OFFICIAL NOTIFICATION OF DECISION

Project# PR-2021-005473

SI-2021-00709 SITE PLAN

**LOT 24 UNIT 1, LADERA BUSINESS PARK
SUBDIVISION** zoned NR-C, located at **7801 LA
MORADA PL and UNSER** containing
approximately 2.7 acre(s). (H-9)

### SITE PLAN

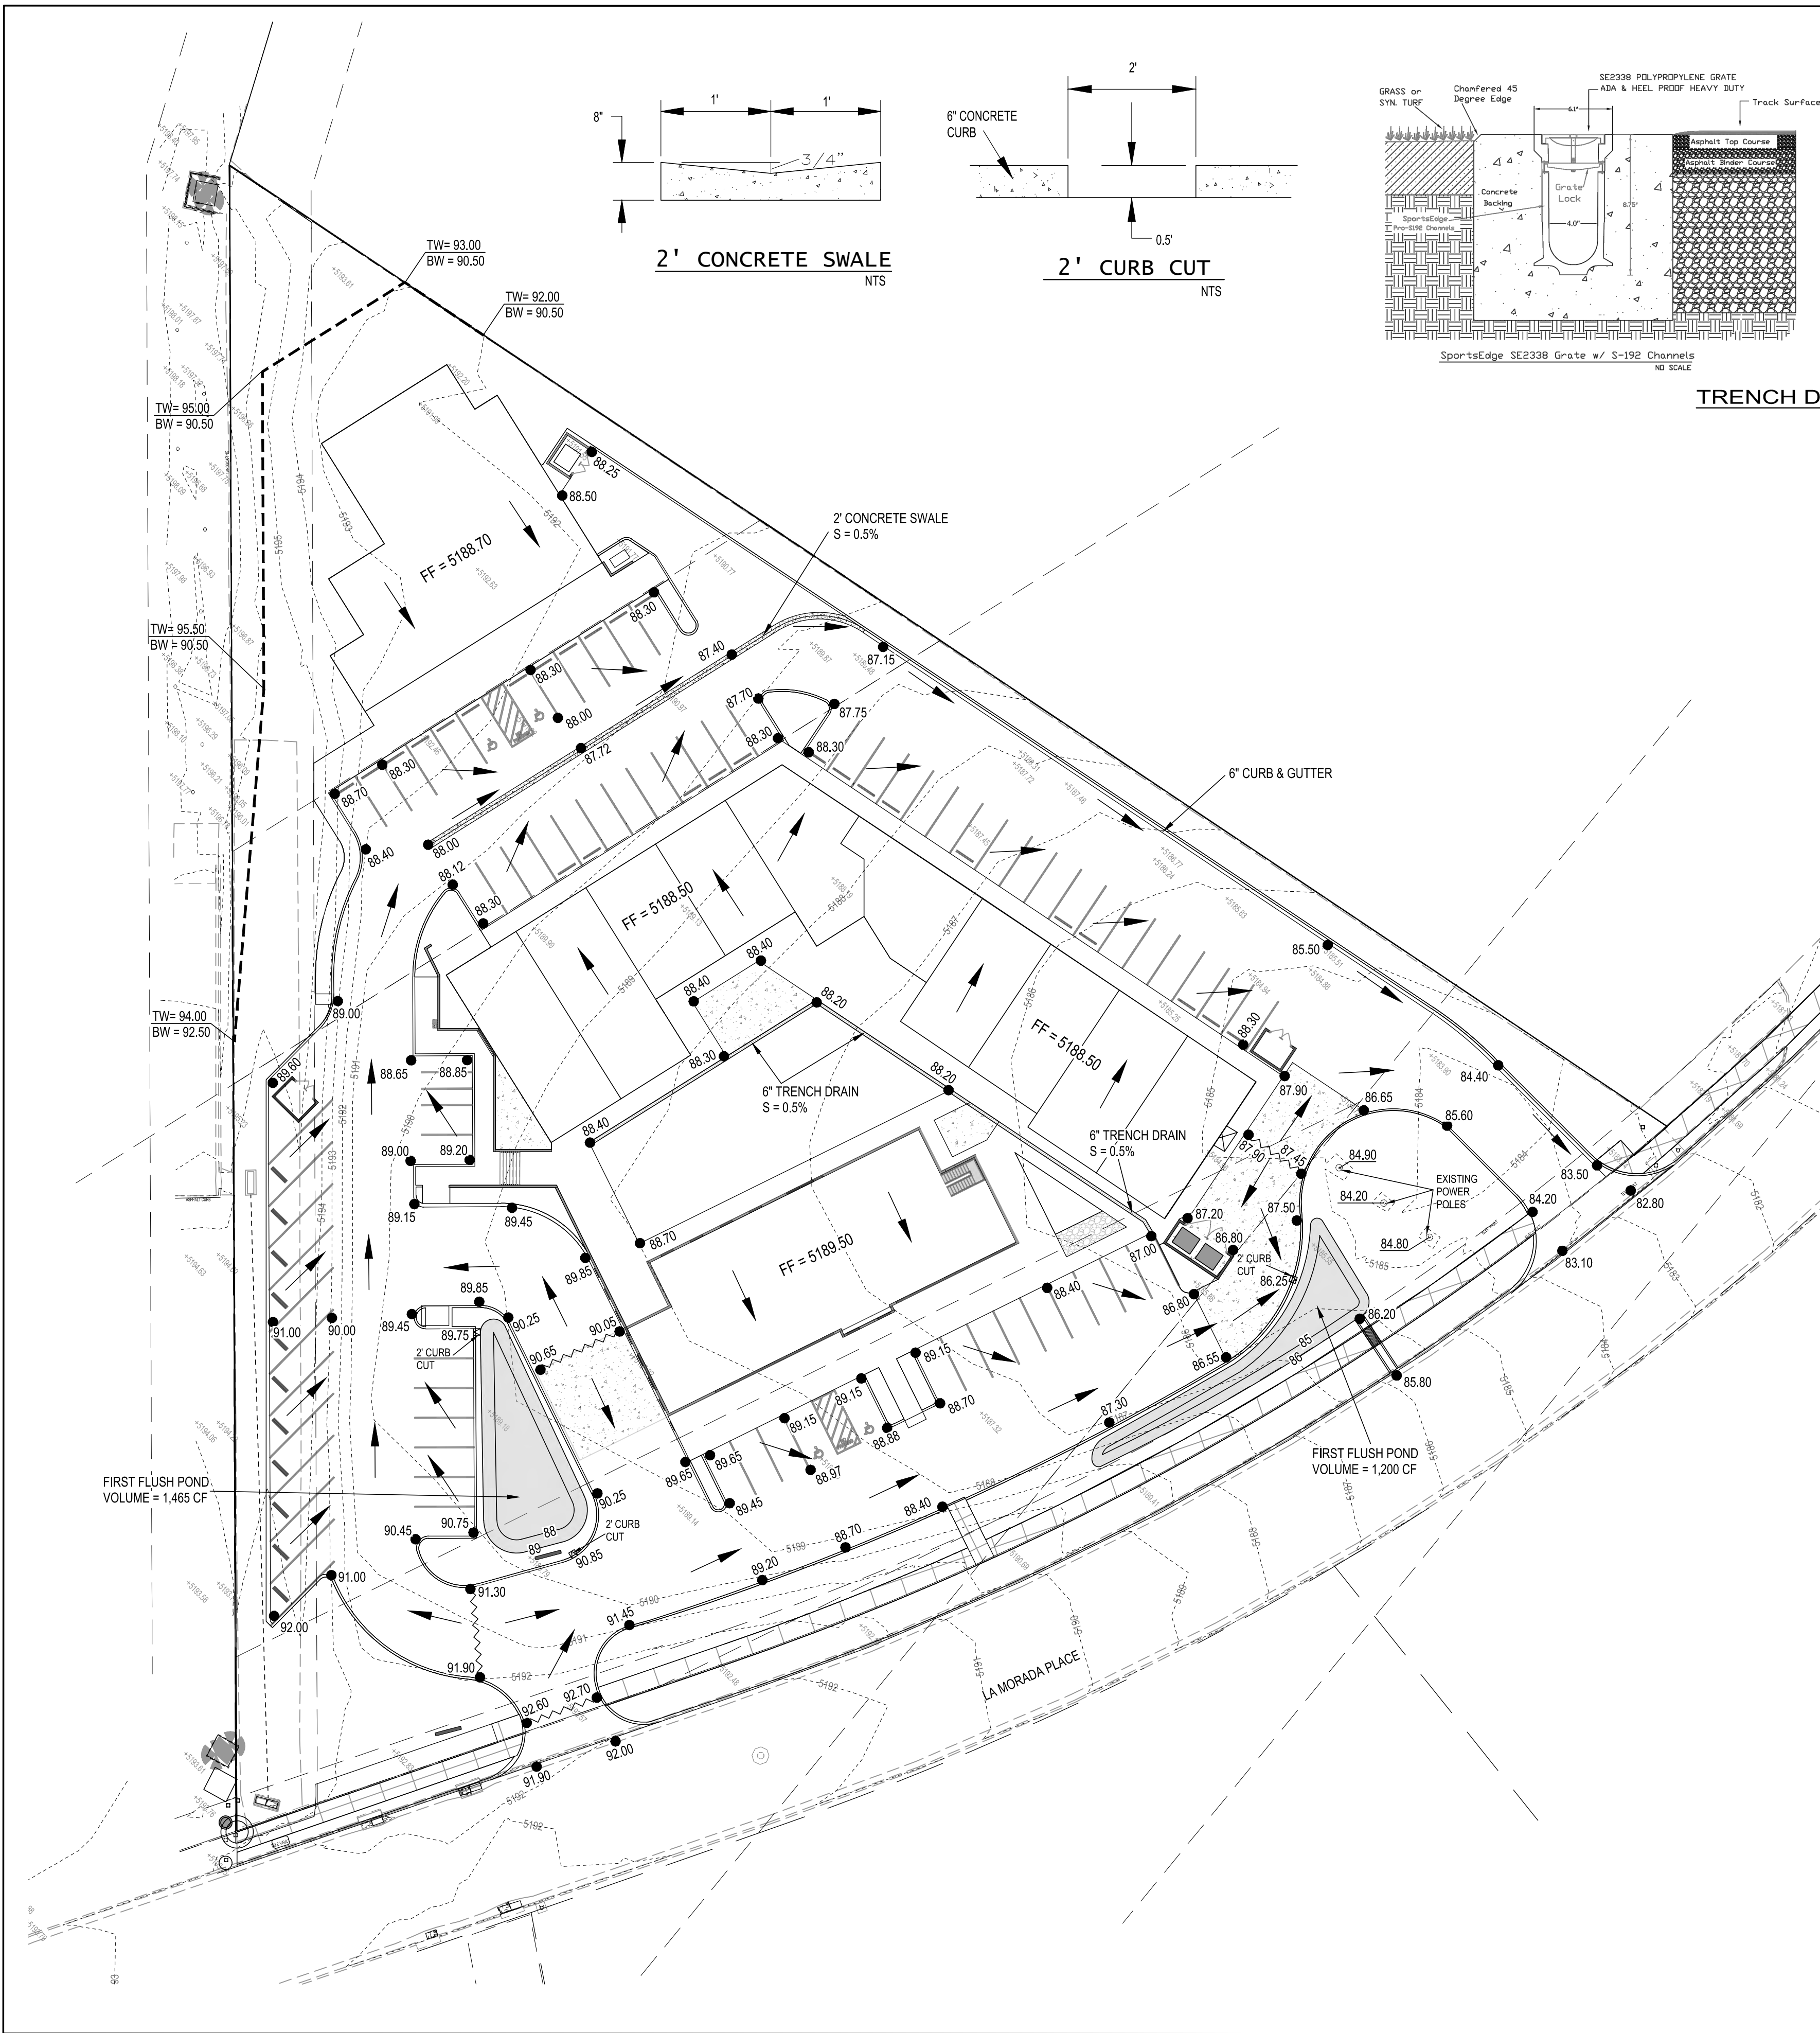
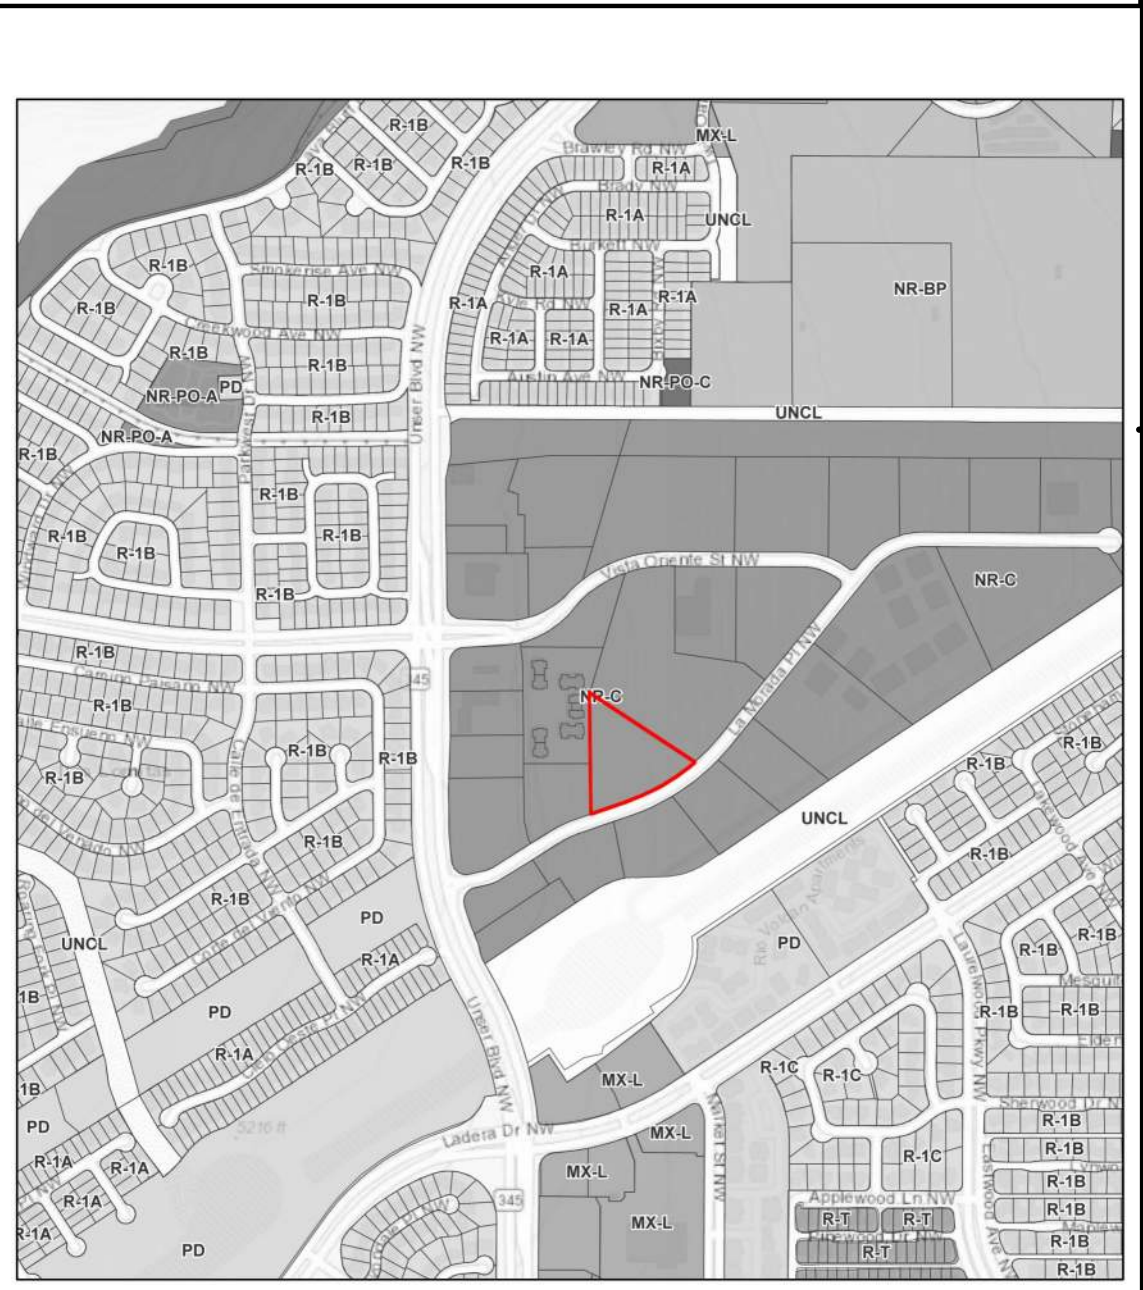
1. This Site Plan is valid 7 years from DRB approval (11/17/2021). An extension may be requested prior to the expiration date.
2. Final sign off is delegated to Transportation for bike rack detail, to provide a complete 6 foot ada pathway throughout the site, to call out curb locations, provide details on clear site triangles per comments, and to work out the details within the public right-of-way regarding the sidewalk, curb ramps and driveways.

3. Final sign off is delegated to Planning for notes to be added to the site plan indicating that all specifications of the Ladera Business Park must be met, with items such as site lighting, dumpster detail, and building design being referenced, for Solid Waste signature, the professional signing of plan sheets, and verification of grading. if the site has not been graded, a Sensitive Lands Analysis shall be provided.
